Application Ref:
73263/APP/2017/3838

High Speed Rail (London - West Midlands) - Schedule 17 - Planning Work

Plans and Specifications submission under Schedule 17 of the High Speed Rail (London - West Midlands) Act 2017 for an ecological mitigation scheme comprising earthworks, including one no. mitigation pond, two no. hibernaculum and one no. reptile basking bank, together with permanent fencing and one field gate.

Location of development: Colne Valley Viaduct, Wetlands Ecological Mitigation Site, Harvil Road, Harefield,

TYPICAL REPTILE BASKING BANK CROSS SECTION

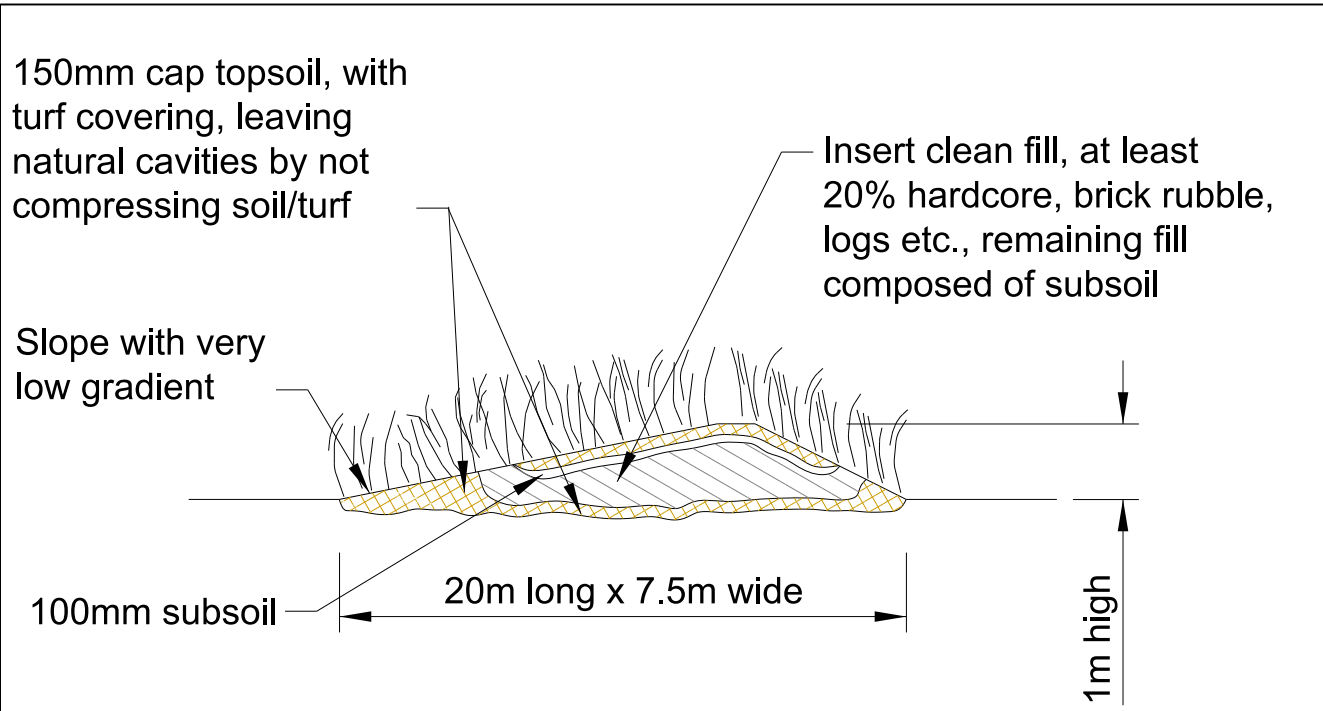
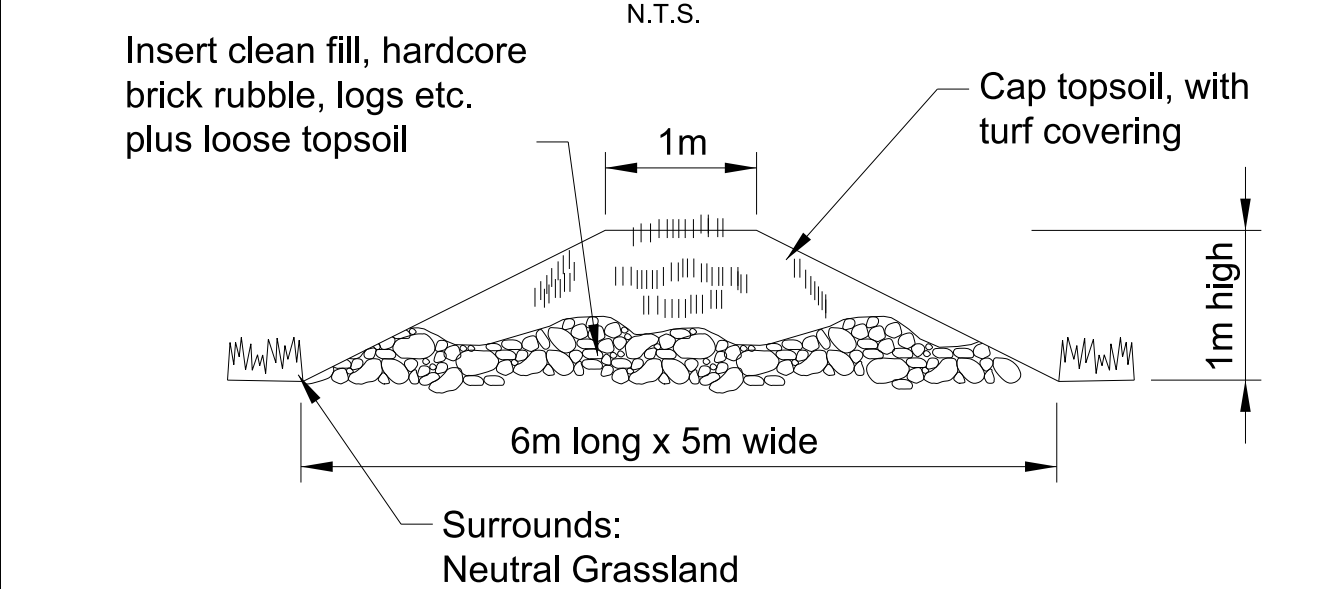
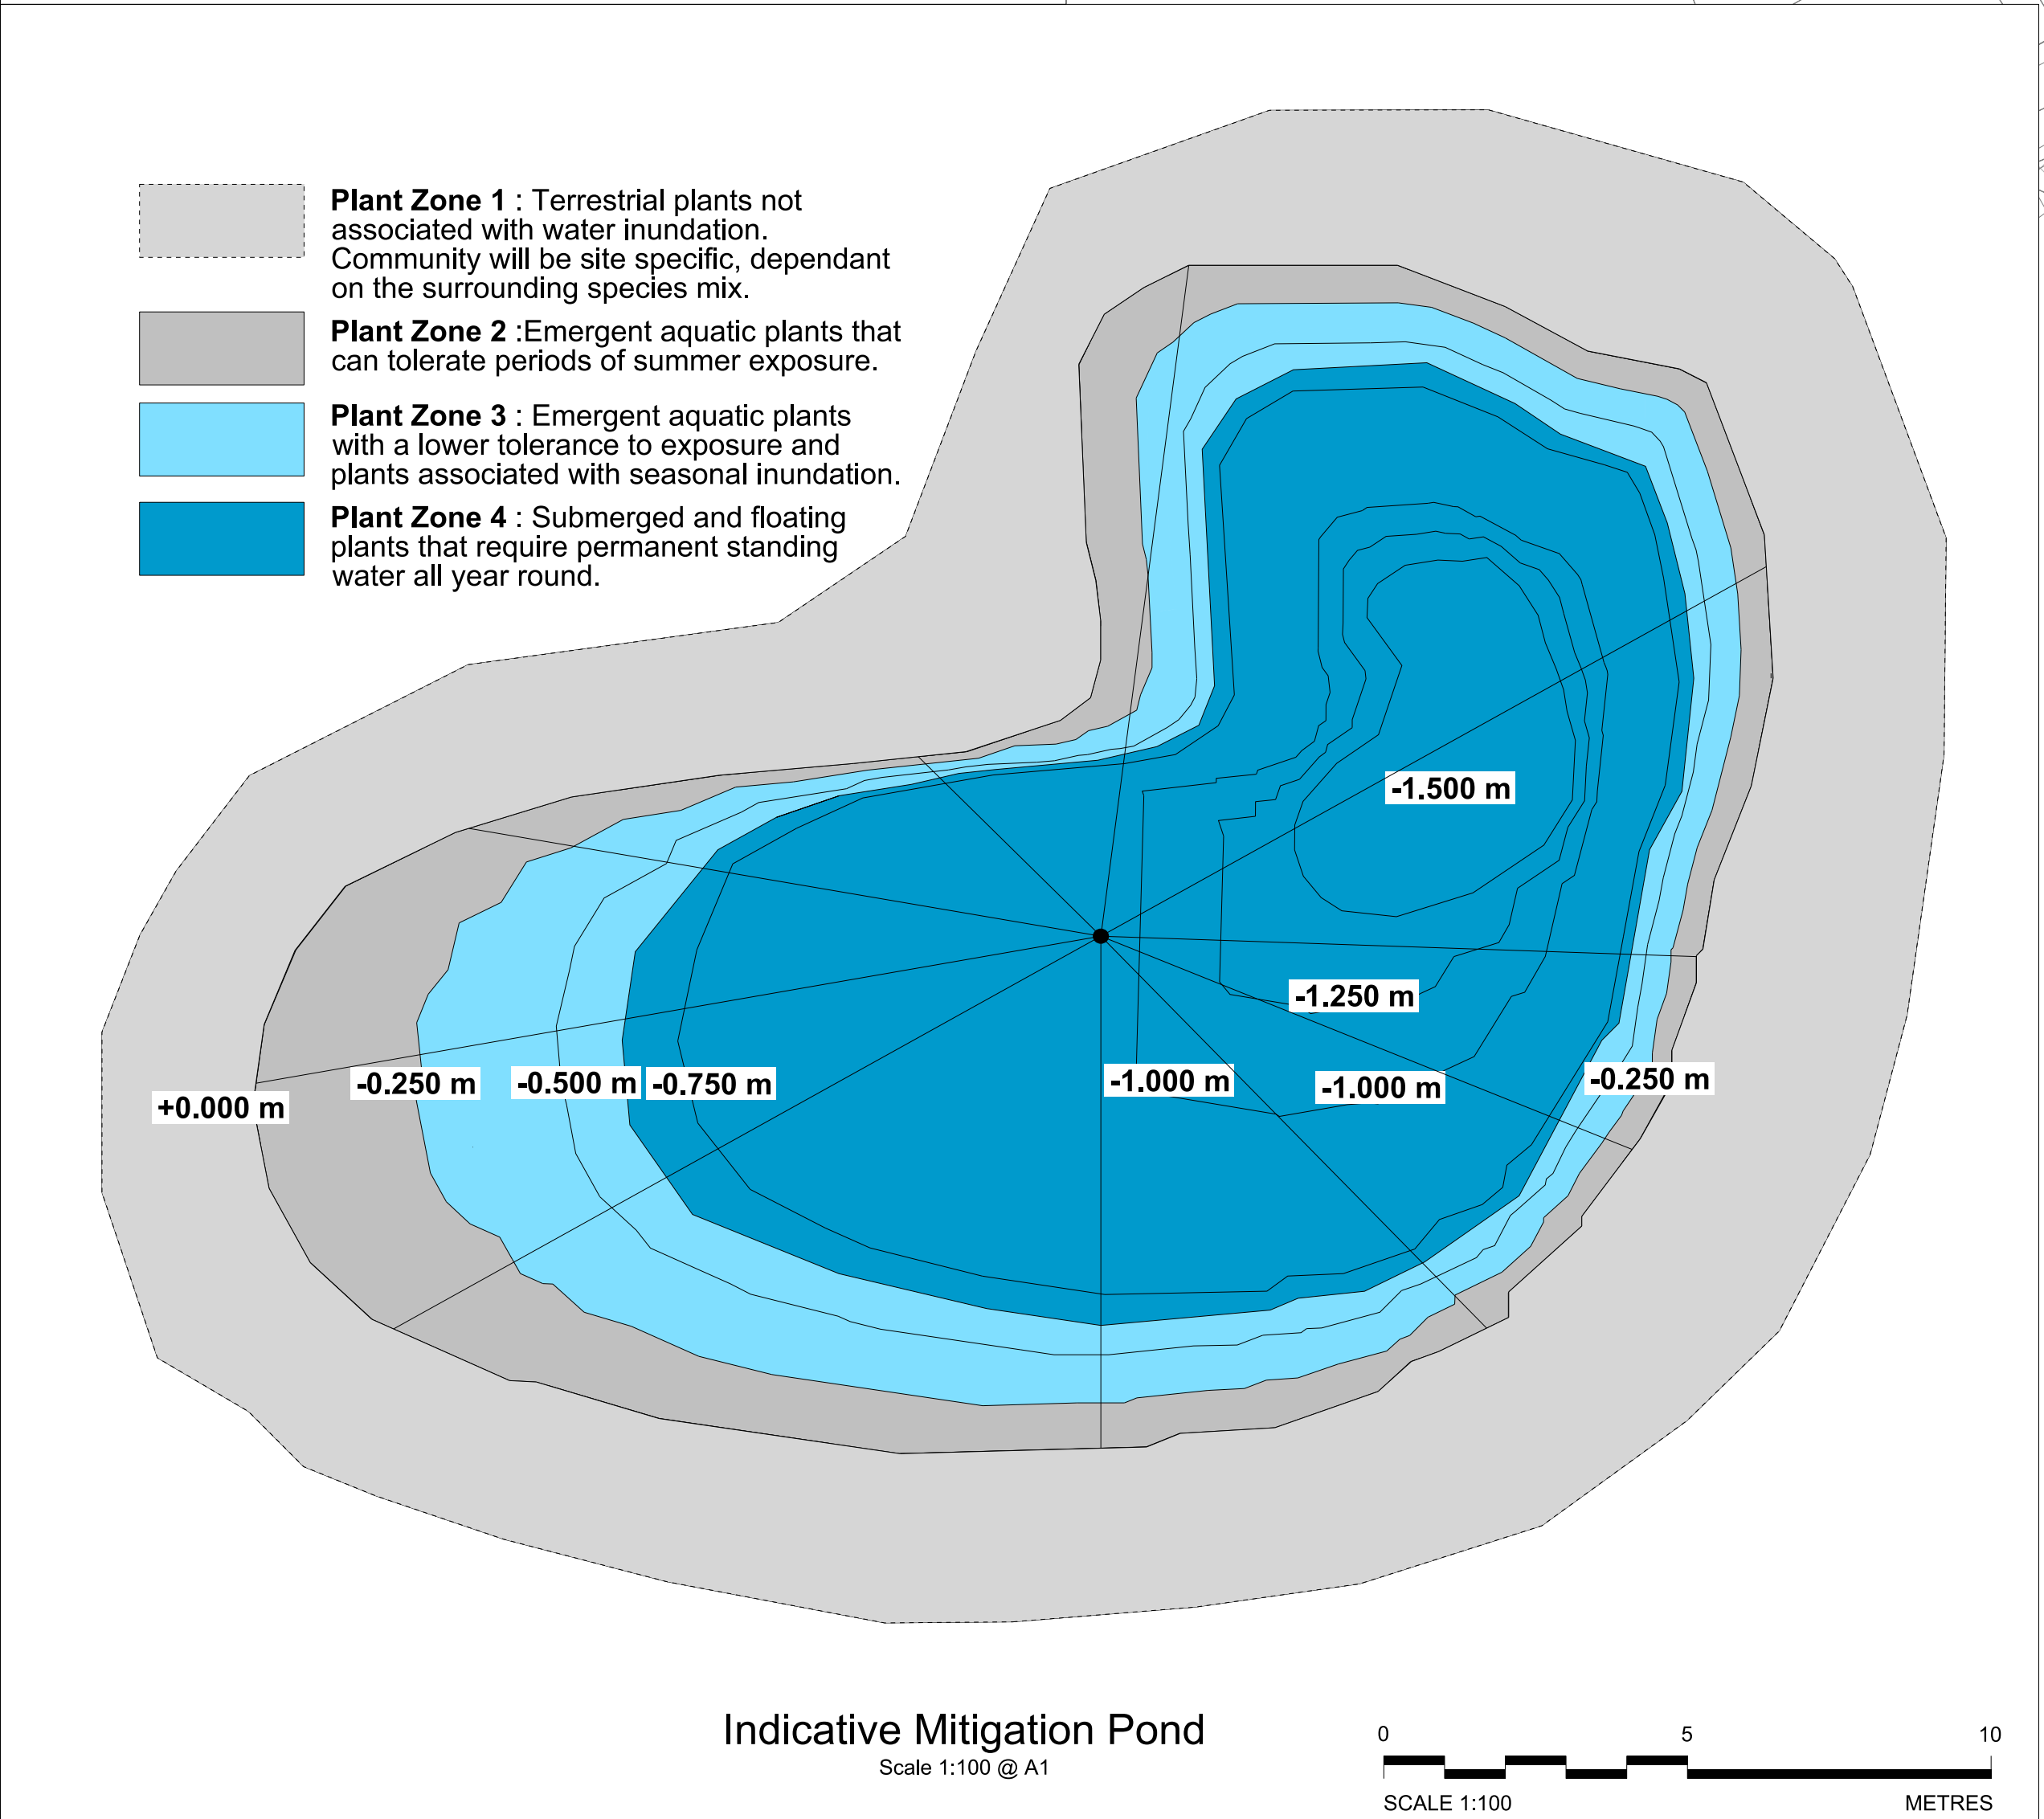
1. The design or external appearance of the works ought to, and could reasonably, be modified to preserve a site of archaeological or historic interest or nature conservation value.
2. The development does not form part of a scheduled work, within the meaning of Schedule 1 of the HS2 Act, and that the development ought to, and could reasonably, be carried out elsewhere within the development's permitted limits.

The Council does not consider the details relating to landscaping, ecological planting and site restoration are adequate as presented. The information submitted is not adequate to fully understand what HS2 Ltd is trying to deliver by way of landscaping or restoration. The restoration package needs to be far more detailed prior to the Council confirming the approach is adequate. The details should include but not be limited to:

- Pond lining (puddled clay preferred)
- Soft landscape proposals include schedules, specifications and appropriate planting plans
- Management and Maintenance plans and schedules
- Hard Landscape details (fences, gates, tracks and ancillary works)
- Long term access arrangements for maintenance
- Site security measures
- Ecological enhancement plan showing the interaction of the site with the surrounding area
- Detailed proposals for land ownership and responsibilities
- Detailed information on how the pond will be filled and levels maintained
